SUBJECT: Engineering Review Comment
Mountain View Electric Association Inc. (MVEA)

Project Name: Urban Landing – PUD/Preliminary Plan

Project Number: PUDSP243

URBAN LANDING
 PUD DEV. PLAN & PRELIMINARY PLAN
 SITE PLAN SHEET

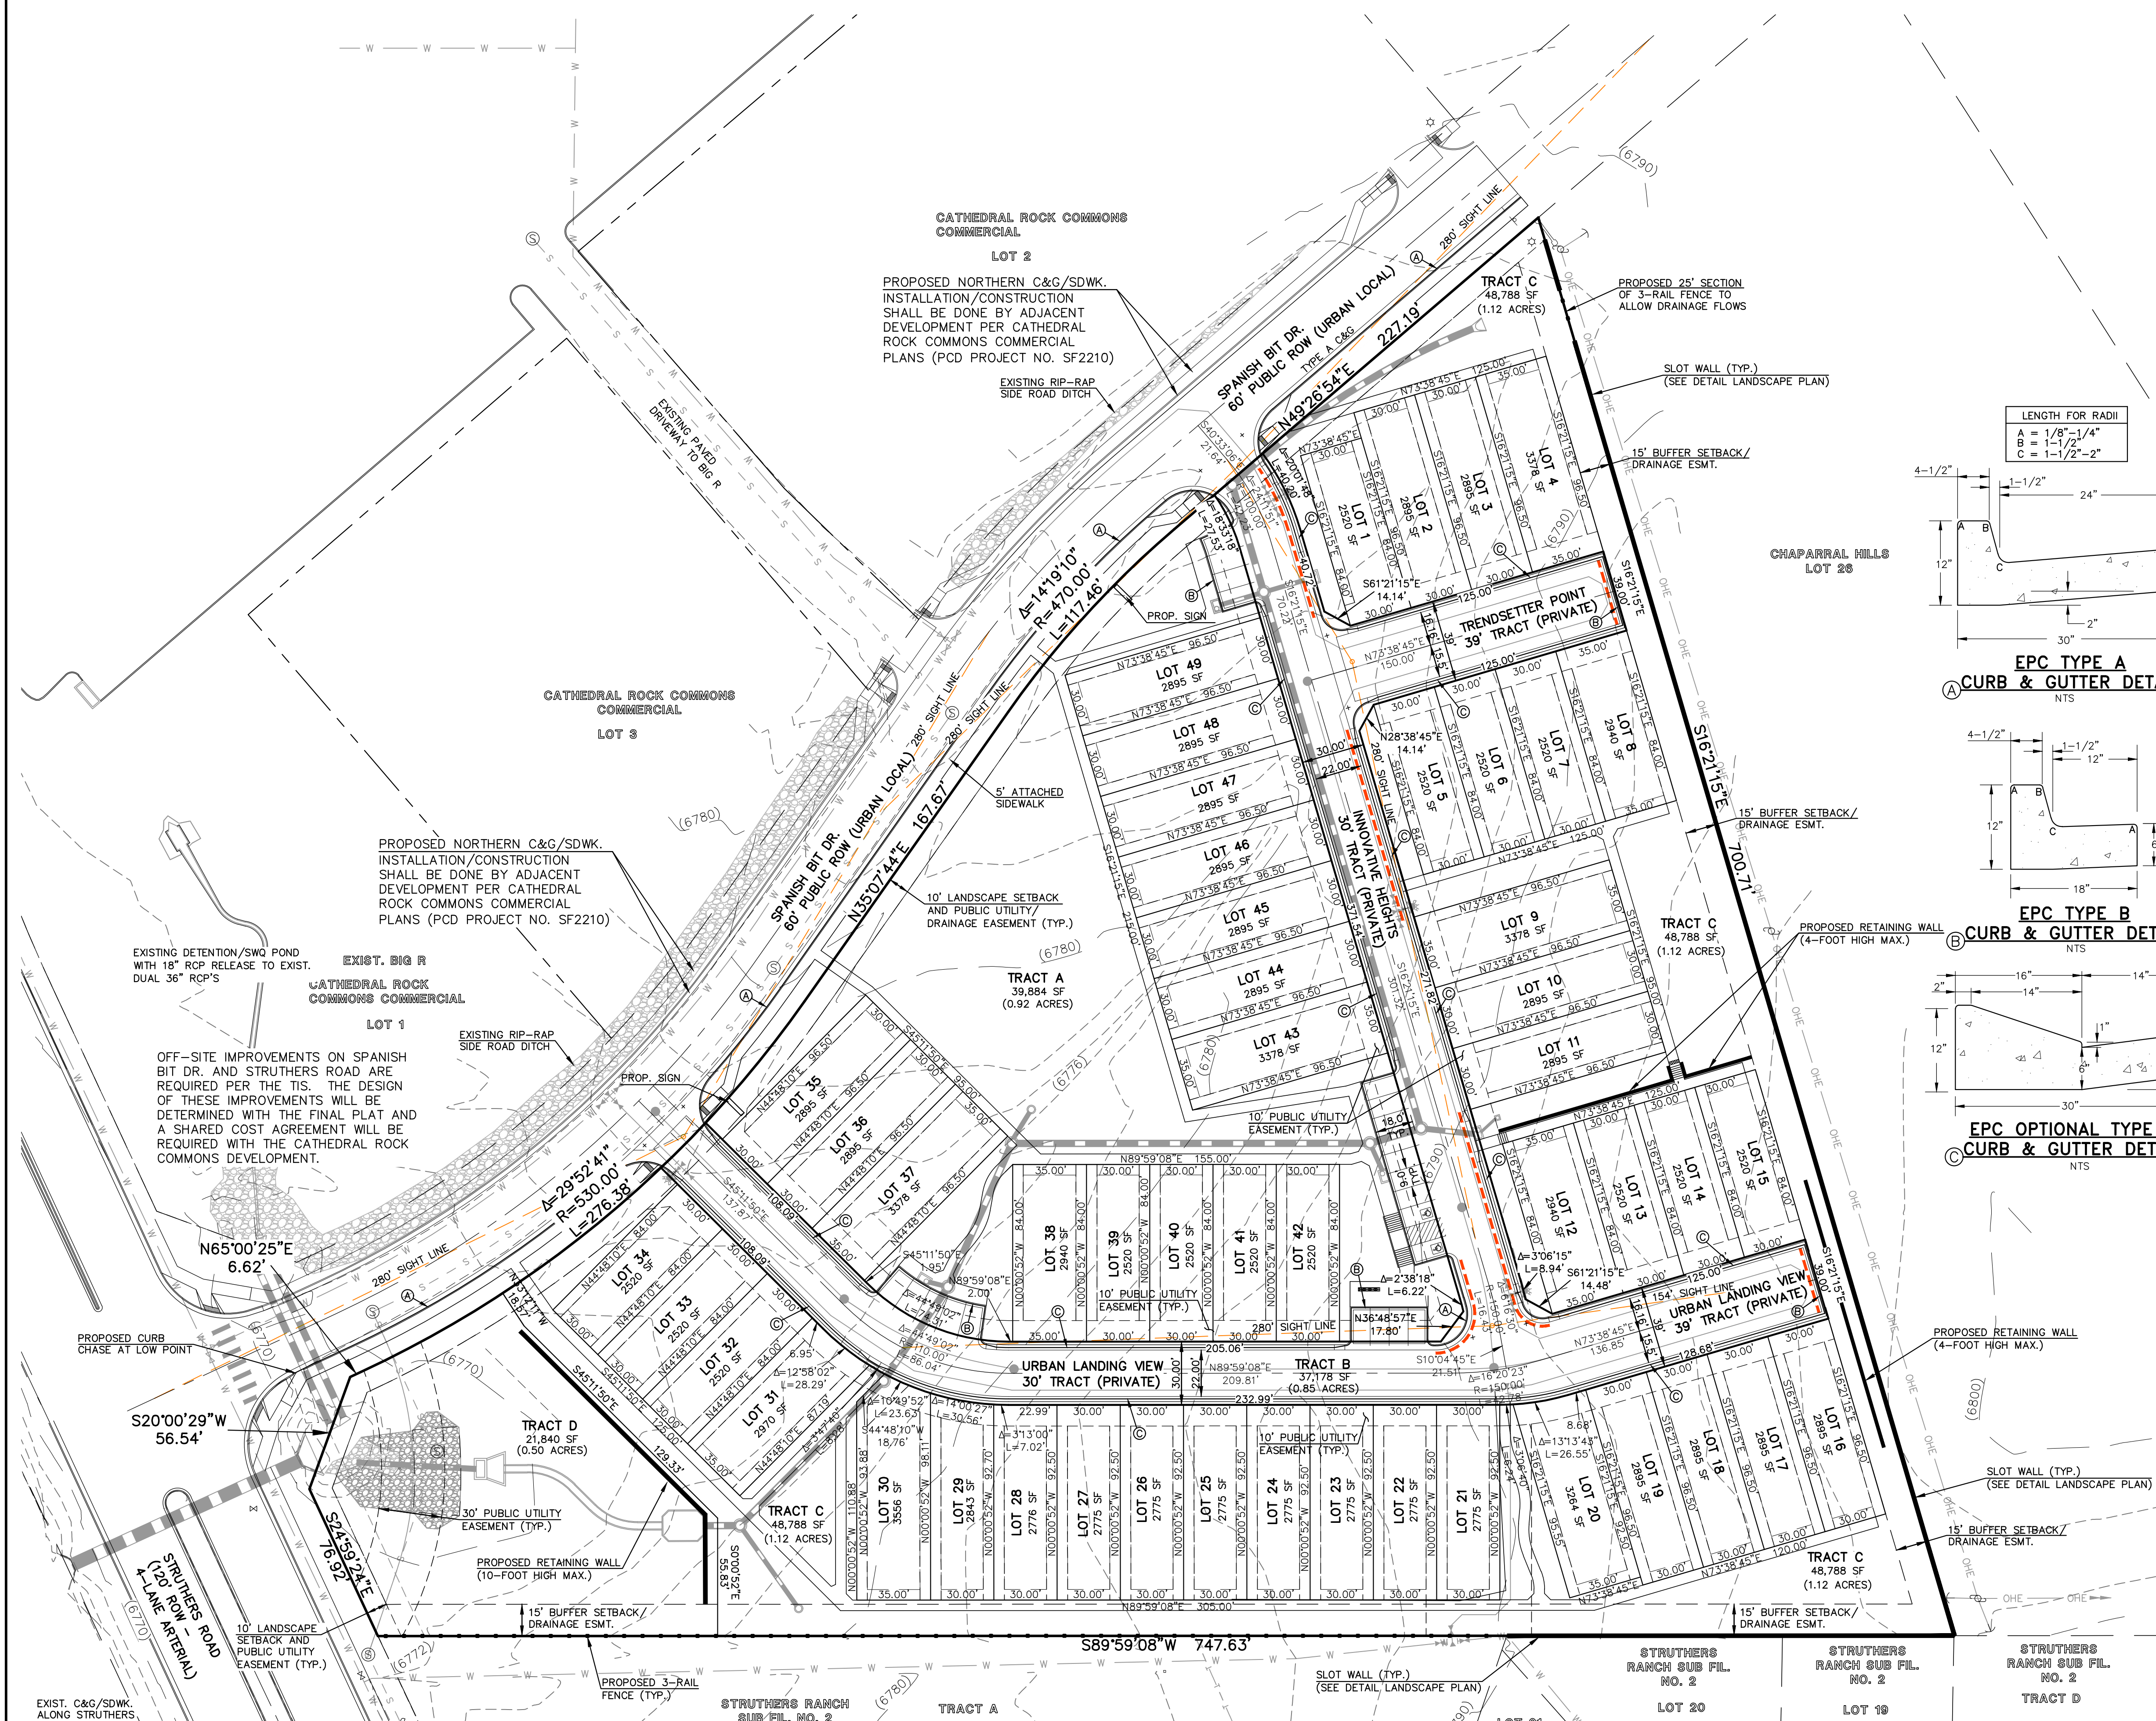
MVEA requests a ten (10) foot front lot utility easement, a five (5) foot side lot utility easement, and a ten (10) foot rear lot utility easement along with a twenty (20) foot exterior utility easement on the plat and all tracts include easements. MVEA also requests the platting of MVEA's existing facilities with easements on the plat. Additional easements may be required.
